Our reference: ECM: 9250127
Contact: Gavin Cherry
Telephone: 02 4732 8125

Response to Notice of Amended Plans and Amended Supporting Information for Kemps Creek Warehouse Logistics and Industrial Facilities Hub (SSD 9522)

Figure 1: MSP Estate Subdivision Plan (subject to SSD-9522 MOD 1)

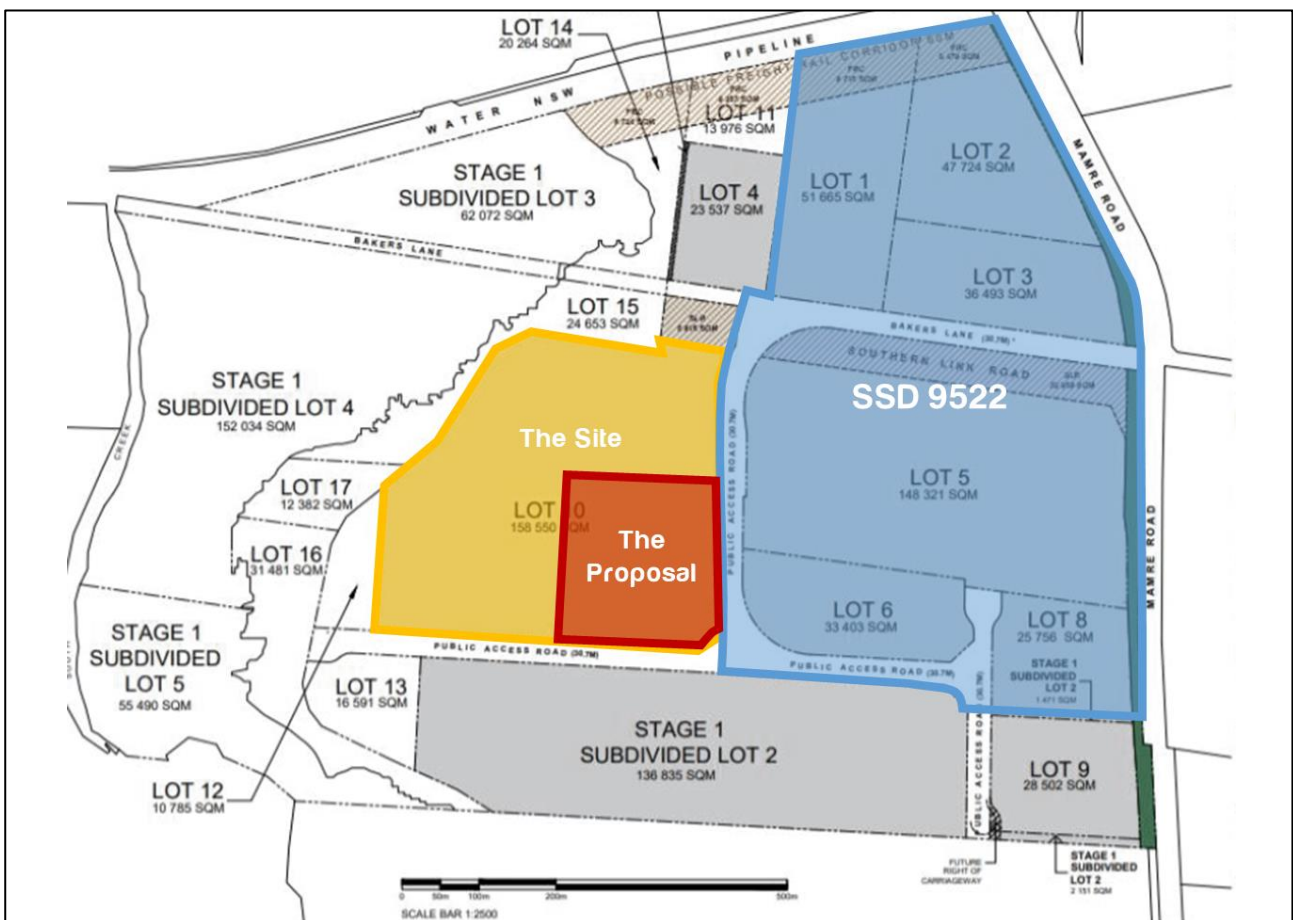
The amended proposal seeks the subdivision of the RE1 zoned land to separate it from the RE2 zoned land. This is of concern as the intended form and function of the RE1 zoned land separate from the RE2 zoned land is not yet known. The proposal sets up for severance of a connected open space corridor by virtue of separate lot creation. While the creation of Lot 14 in isolation is likely necessary due to the existing severance of the crown road and LRS registration requirements, it is recommended that Lot 15, 16 and 17 be amalgamated into a single allotment until such time as more detailed master planning is progressed for this part of the site, to better understand the intended ownership, embellishment and use of the entire open space corridor. It is noted that this could be addresses as a condition of consent.

The proposed plan of subdivision identifies a possible freight corridor alignment to the immediate north of the site, with a nil boundary setback proposed from the car parking an manoeuvring areas to the identified corridor.

It was understood that the rail corridor was expected to be between 60-80m in width, which would suggest that the identified corridor width and resulting spatial arrangement adjoining the indicated corridor may not be sufficient. Any future or planned adjustments in the corridor alignment will have implications on the spatial arrangement of the development and parking car arrangements on Proposed Lot 1 and 2. It is recommended that the corridor alignment and associated corridor width be confirmed and agreed to by the relevant stakeholders.

The proposed amended Stage 2 plan of subdivision now proposes Lot 11, Lot 12 and Lot 13 as separate lots for bio-basins which are outside the RE1 zoned land. Council supports the retention of private infrastructure within the development (and not within RE1 zoned land) as Council has not accepted any suggestion for dedication of private water management infrastructure. In conflict with the plans however, the amended Civil Design report still makes numerous references to Council taking on asset ownership and management through dedication which should be rectified.
